## follow up on D Street sidewalk installation

I am following up on communication you had with the former City Planning Director, Tuck O'Brien, about the design of a sidewalk to be installed within the right-of-way on the east side of D Street adjacent to your property. This sidewalk work is currently planned for this summer.

VALLEY STREET & "D" STREET INTERSECTION
SCALE: 1"=10'

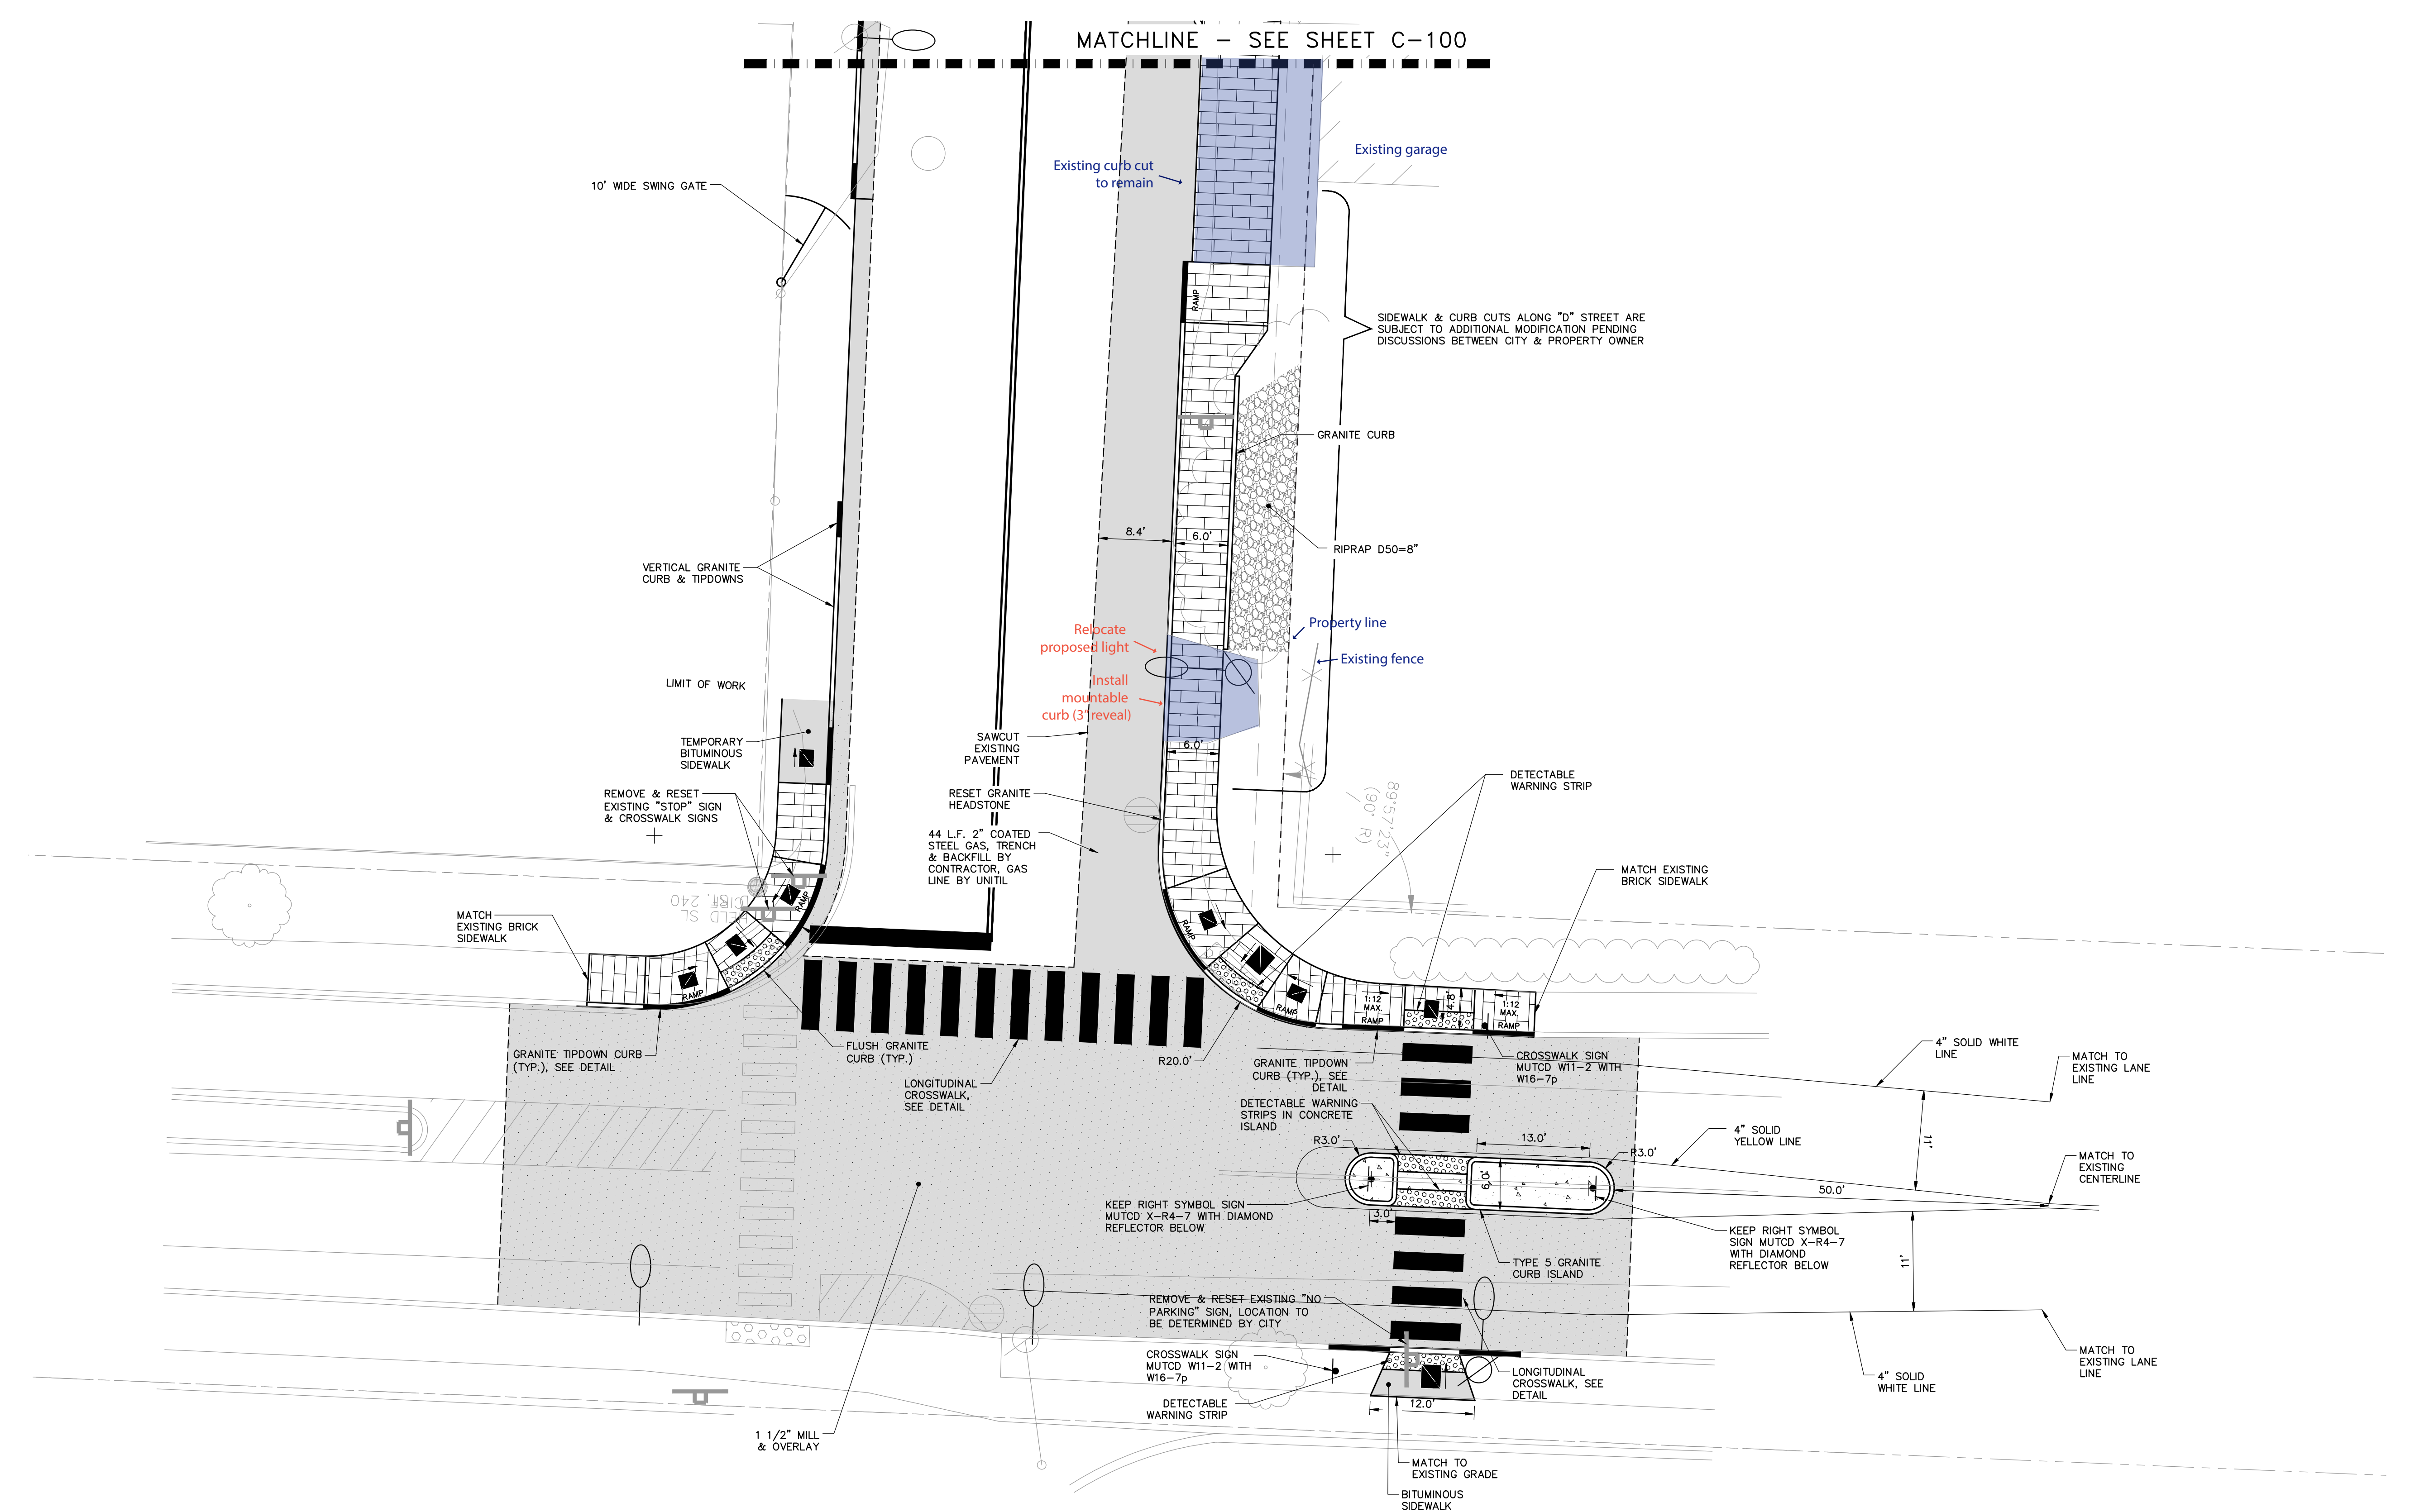
As you're aware, the plans for the sidewalk maintain the curb cut in front of the small garage structure on your property adjacent to D Street, as well as the adjacent driveway (see at the top of image below). However, the plans propose to close the easternmost D Street curb cut to your property nearest Valley Street (see at bottom of image below).

We are aware through previous correspondence that closing this easternmost curb cut has raised concerns for you. As an alternative, DPW has suggested that mountable curb with a 3" reveal (less than the standard 6" curb reveal) could be used at this curb cut location. This design is common in areas of the city with significant loading activity, and would allow you to access the street through that location on an intermittent basis if and when you need it. (Based on the condition of the curb cut today, this seems consistent with its current use?) See the notes on the graphic below for clarification.

I am following up with a technical drawing showing a proposed mountable curb design at the site of your existing curb cut near Valley Street. Please let me know if you have questions or concerns on this. As I mentioned previously, MMC is planning to install the sidewalk on the northerly side of D Street this summer.
